Application for Removal or Variation of a Condition following Grant of Planning Permission or Listed Building Consent

Erection of new entrance foyer and single storey side extension, including new access path and ramp.

10494/APP/2024/1634

variation of condition #2

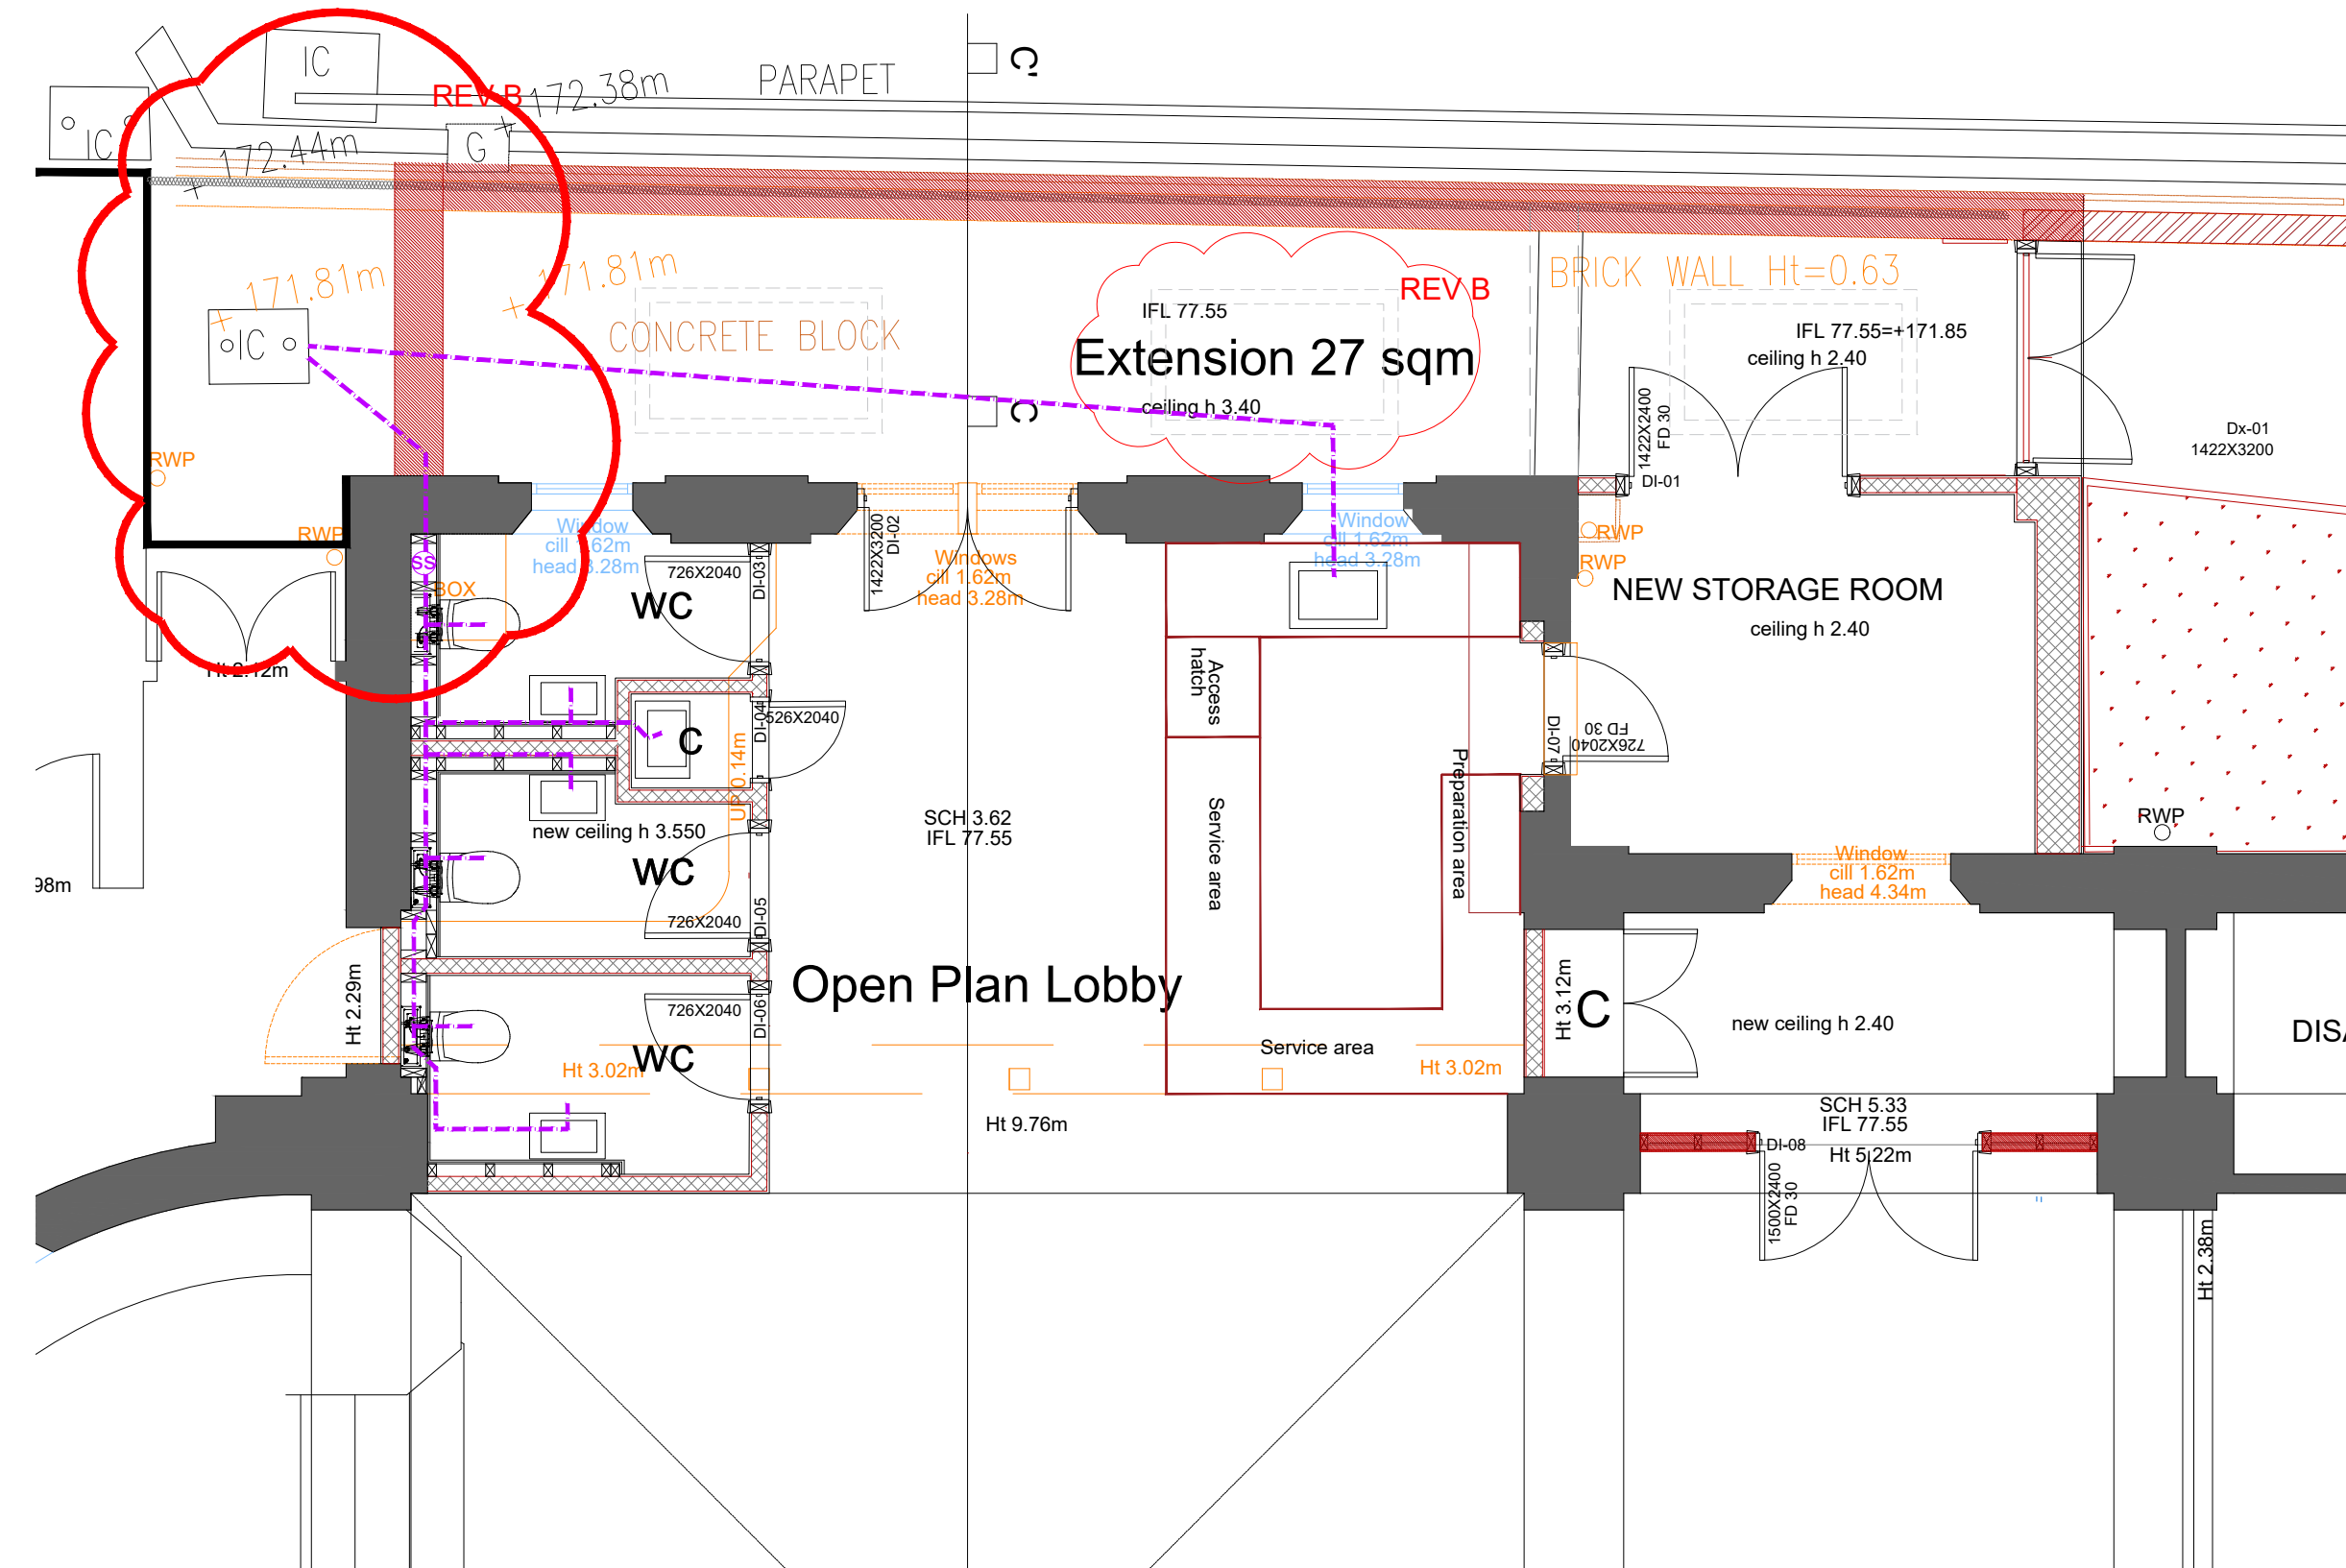
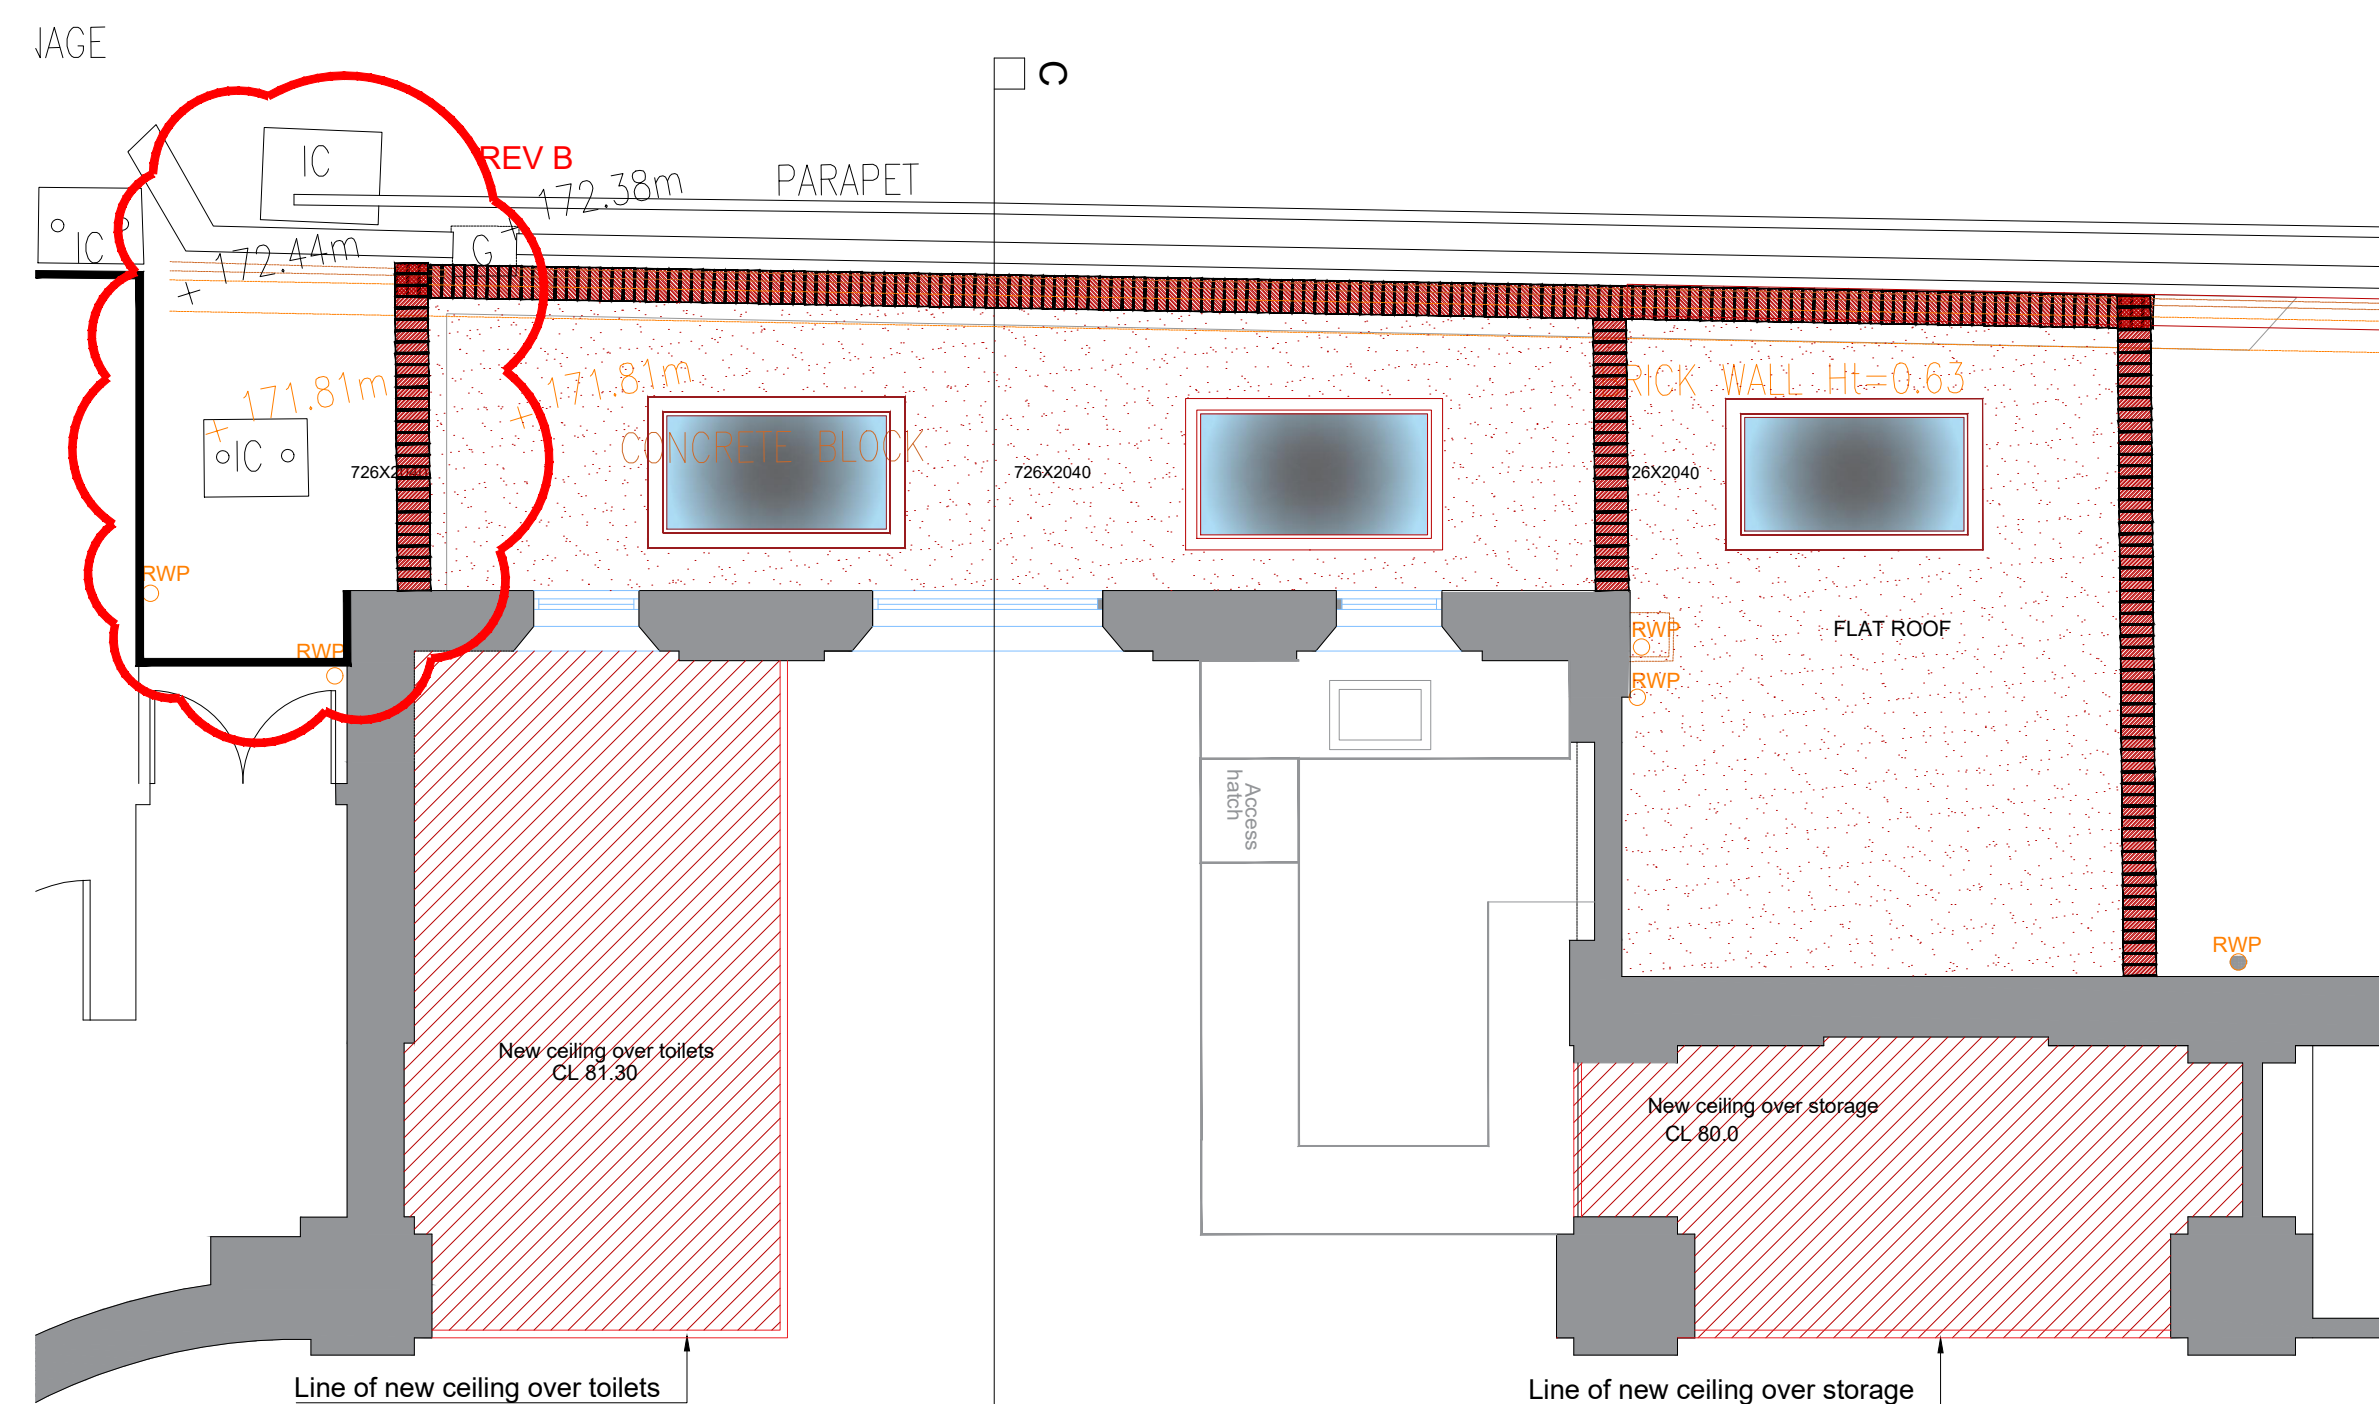
Due to Thames Water constraints

It is necessary to reduce the extension length, add a door at the opposite end, and leave the existing public manhole near the rear building outside the new extension

5530-PL-103 A for the new updated drawing 5530-PL103 B
